DOC20/283033-1

Thank you for the request to the NSW Environment Protection Authority (EPA) for review of the Environmental Impact Statement (EIS) for the proposed Orica Southlands Warehouse Estate (SSD-9691) at 28 McPherson Street, Banksmeadow (Lot 9 DP 1205673).

Figure 10: Site plan (Source: Axis Architectural)

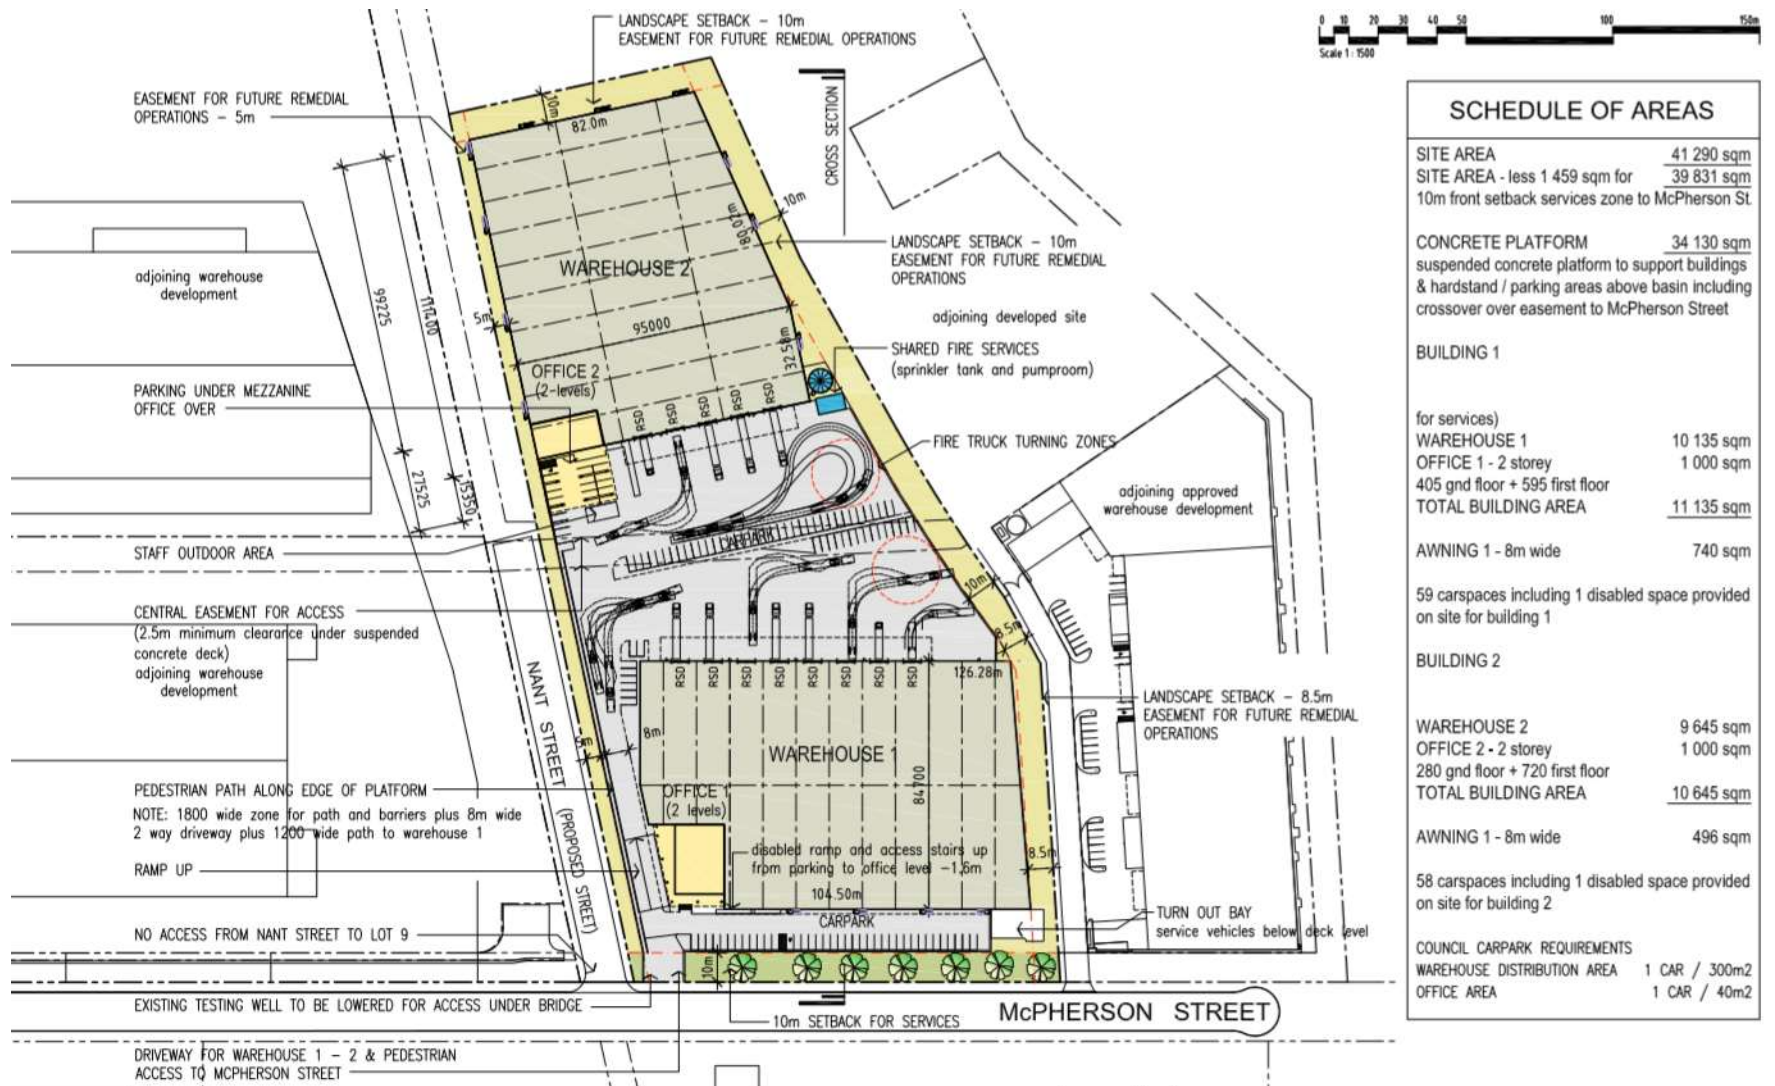
The Environmental Impact Statement (e.g. Figure 10, pg. 34) indicates that easements for future remedial operations are proposed along the northern, eastern and western perimeters of Lot 9 DP 1205673. Furthermore, the Environmental Impact Statement (pg. 31) refers to 'a central easement placed over the site to ensure access arrangements are maintained'.

***Given the importance of maintaining site access, the EPA recommends that the proponent be requested to provide further detail on the proposed easements prior to any project approval being granted.***
